CITY OF PORTLAND

153-A-001

Church Property Commission
360 Canco Road
Portland, Maine 04103

Subject: Parking lot expansion

Attachment 1

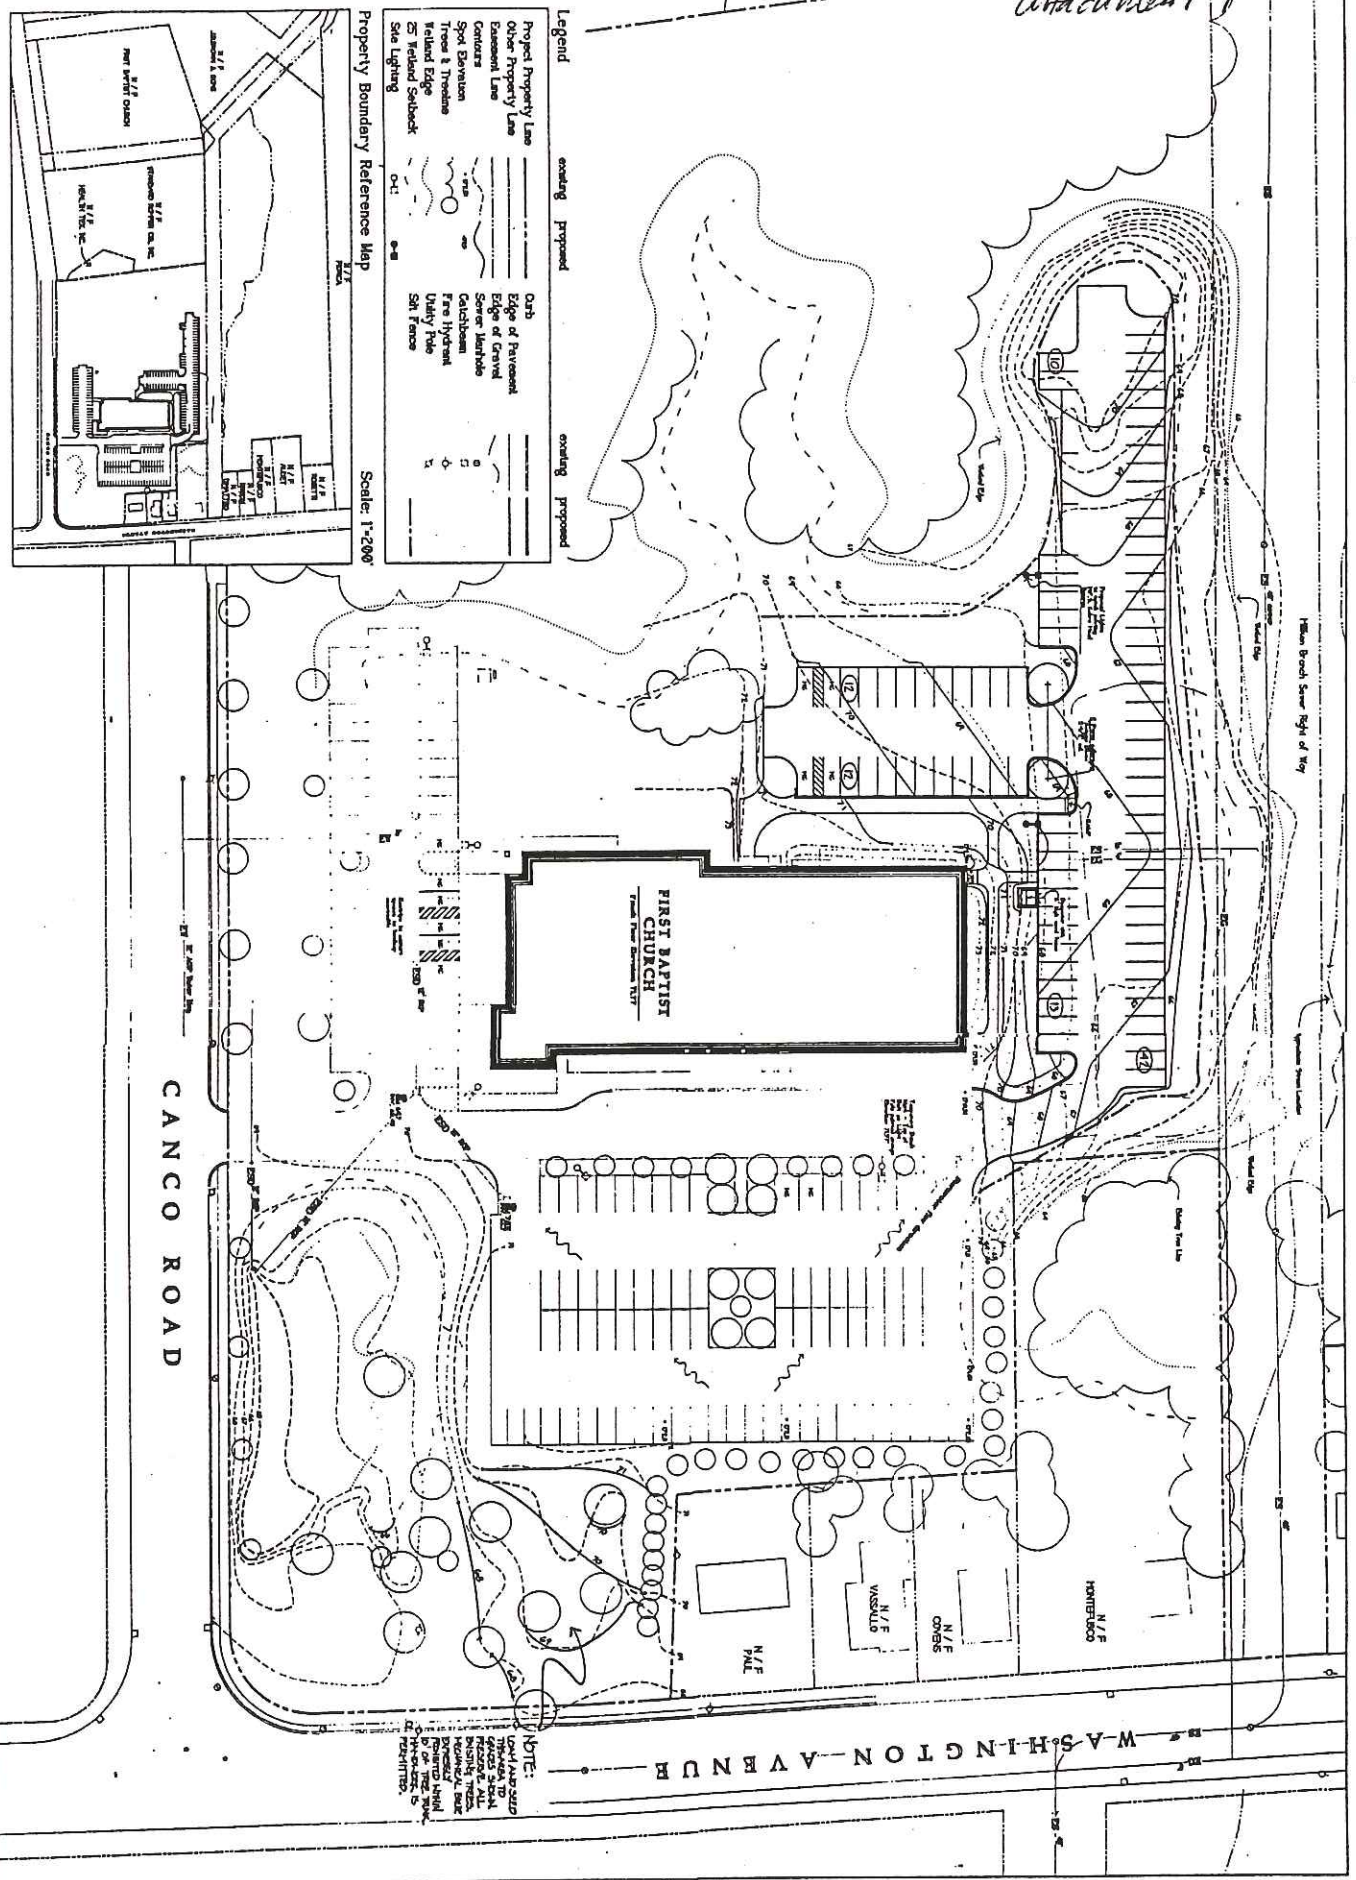
1. Changes to the parking layout: Three parking spaces have been added in the northerly side of the expansion.
2. Changes to traffic circulation: One-way circulation has been built, as opposed to the proposed two-way traffic as shown on the approved site plan.
3. Addition of Lighting: Two new light poles with flood lights have been installed. These were not on the approved plan. In your submittal to the city dated October 31, 2000, note 2 (j) states that "No new lighting is proposed for the parking expansion".
4. Landscaping not installed.

Because your build out does not conform to the approved plan, you must apply to the City for an amendment to your site plan. This should reflect the as-built condition of the changed parking and circulation areas. Also, a photometric plan must be submitted to ensure compliance with city lighting standards.
